Marge Schmuckal - Re: 238 Bancroft St - #2014-01478 - 195-B-023

From: Ken Wilcox <qenwx@yahoo.com>
To: Marge Schmuckal <MES@portlandmaine.gov>
Date: 7/10/2014 9:40 PM
Subject: Re: 238 Bancroft St - #2014-01478 - 195-B-023
Attachments: 238 Bancroft Site Plan.pdf

- Page 1 Description of the shed, picture from Website
- Page 2 Drawing of the placement, same location as old shed
- Page 3 Picture of the house, showing old shed, from the street

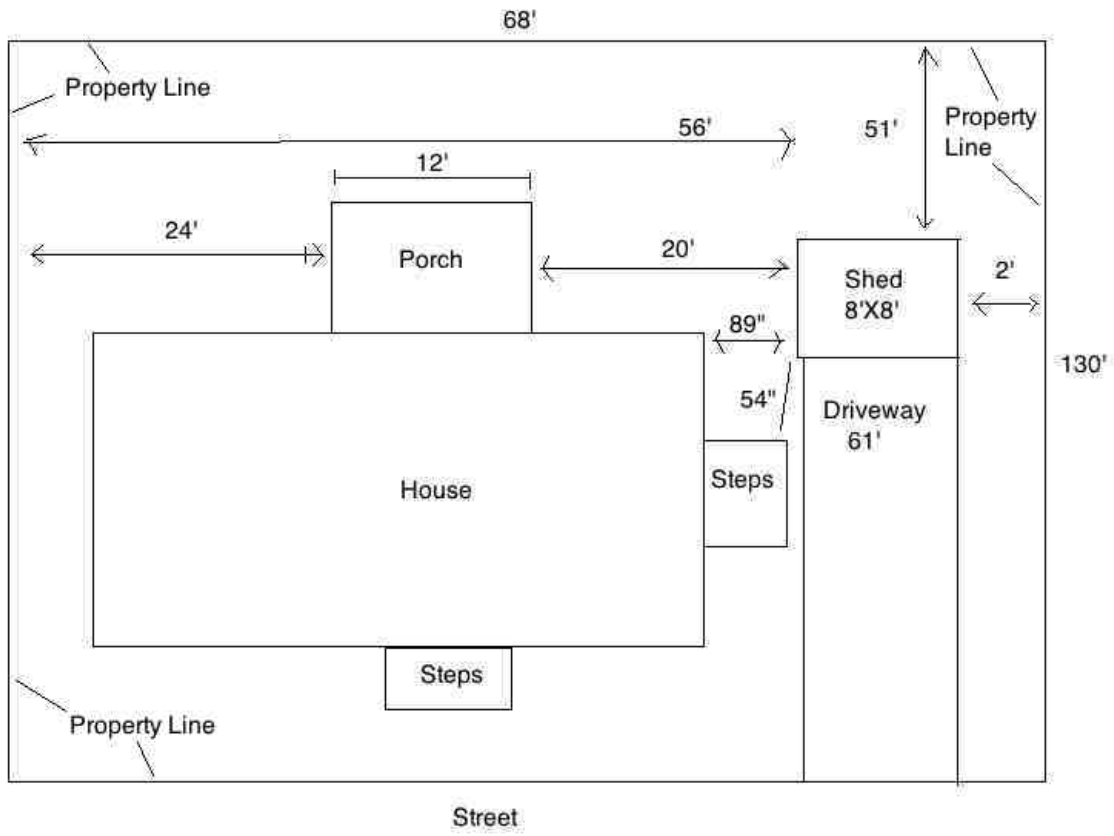
I am reviewing your permit application for an 8' x 8' shed at 238 Bancroft. The minimum setback for this size of shed is 5'. Your plot plan shows 2'. I can not approve your permit at this setback. Can you supply a revised plot plan showing that you will meet the 5' minimum setback. Please note that I checked and there is no permit on file for the previous shed. So there are no legal nonconforming rights for the 2' set back. Your permit is on hold until I can see a plan showing the 5' side yard setback.

I have reworked the placement of the shed to allow for the 5' setback. I have set it 6' back on the new plan. I have attached the Site Plan to this email.
